Department of
Primary Industries
Office of Water

Our ref ER20453
Your ref 08/01659-1

Exhibition of Environmental Assessment for Flyers Creek Wind Farm (MP08_0252)

FIGURE 7.8: Potential Water Crossings North

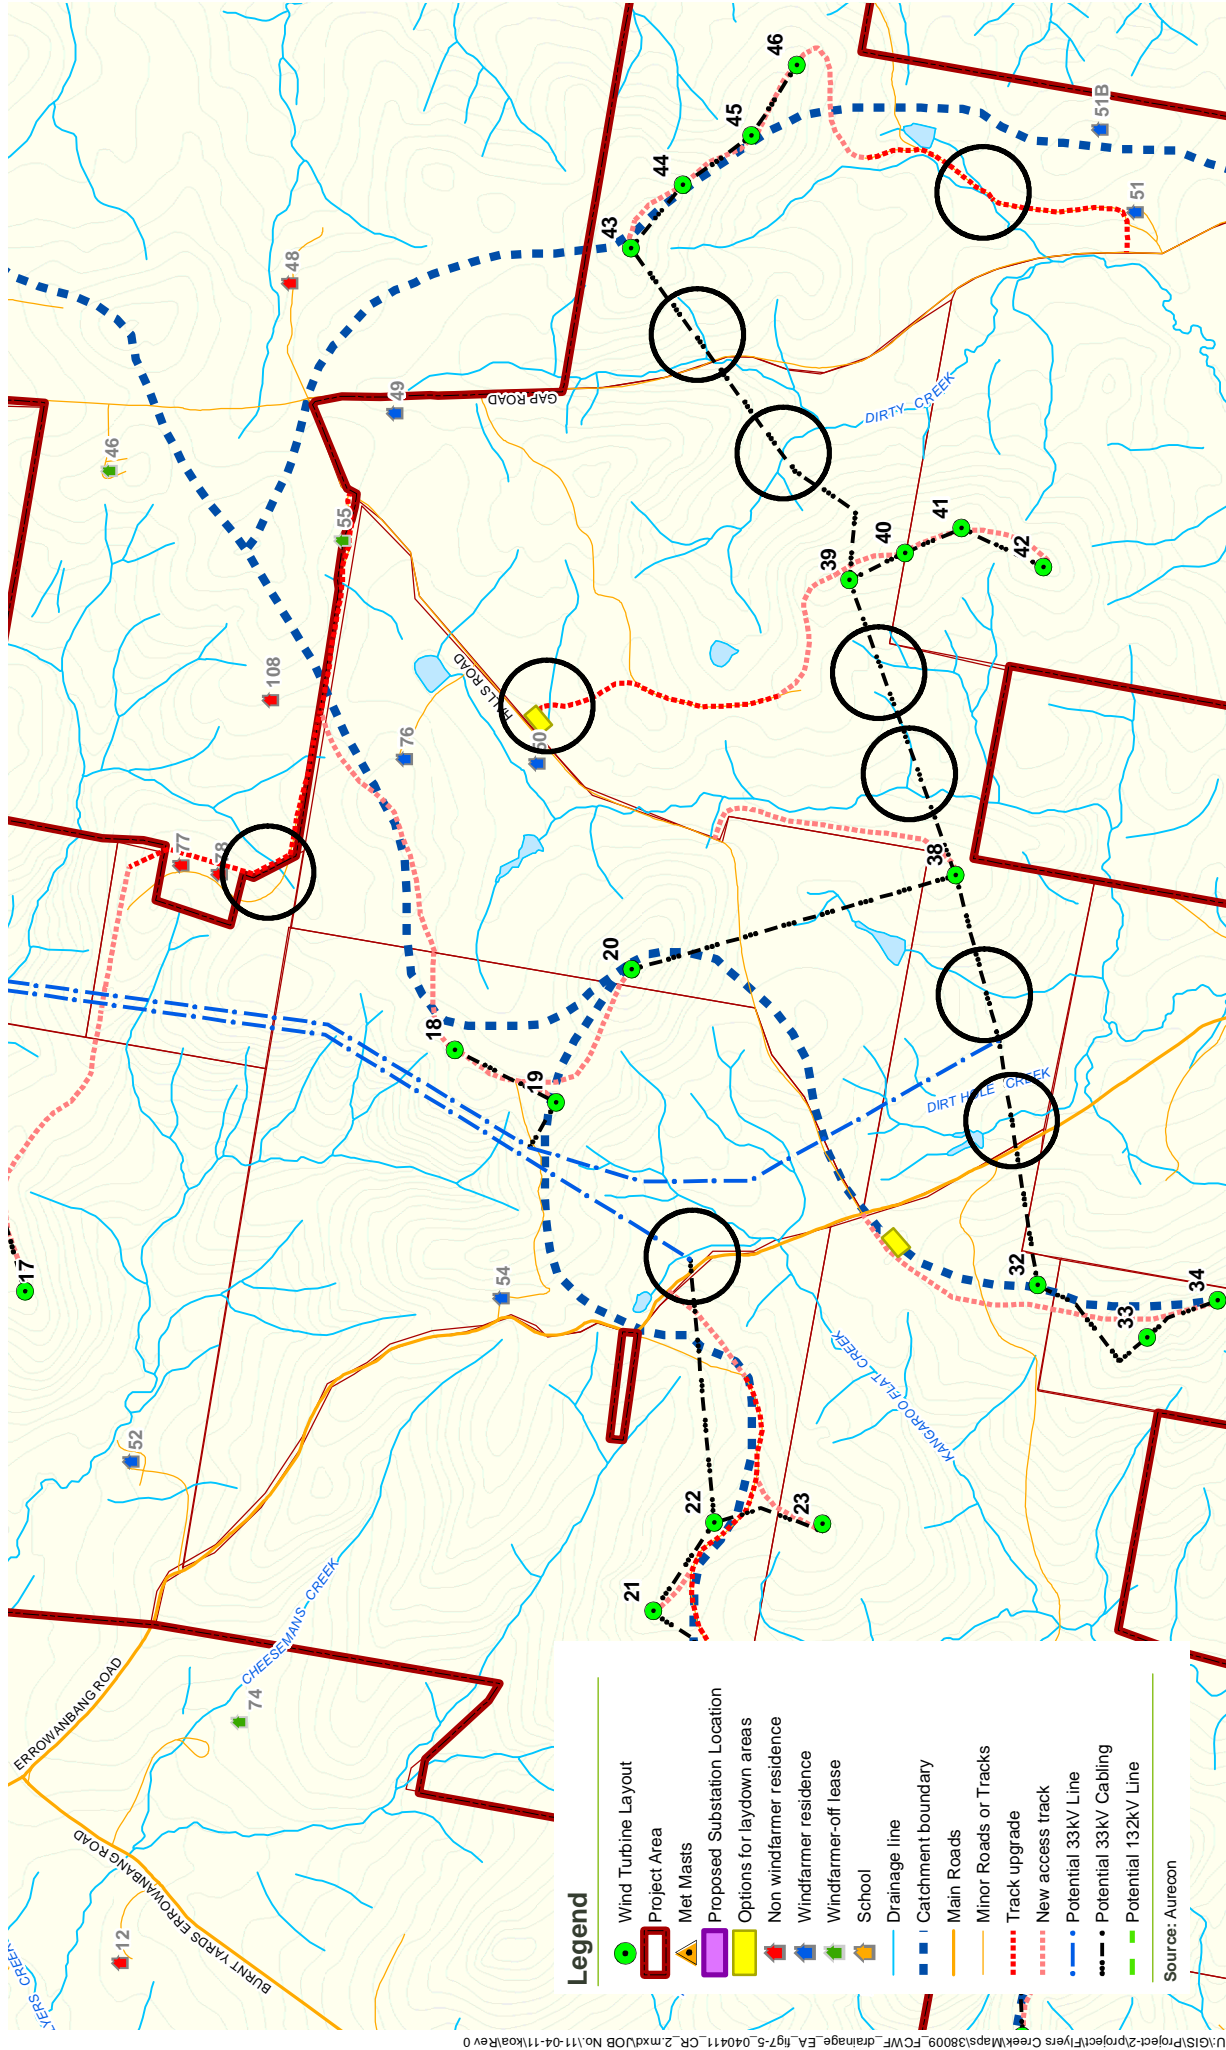
- Office of Water supports the proposal to develop a Soil and Water Management Plan to mitigate impacts to waterways during construction. A key aspect of this plan is the design and mitigating measures for proposed crossing of waterways by cabling or for road crossings as referred to in Section 7.6.3 of the EA. Office of Water recommends these activities be carried out consistent with the *Guidelines for Controlled Activities: Laying Pipes and Cables in Watercourses; and Watercourse Crossings* (Office of Water August 2010) and this to be included as a Statement of Commitment by the proponent.

- The proponent shall prepare and implement a Soil and Water Management plan in consultation with and to the satisfaction of the NSW Office of Water.
- The proponent shall ensure relevant licensing is obtained under the *Water Act 1912* or *Water Management Act 2000* for all activities which intercept or extract groundwater prior to commencement of these activities.
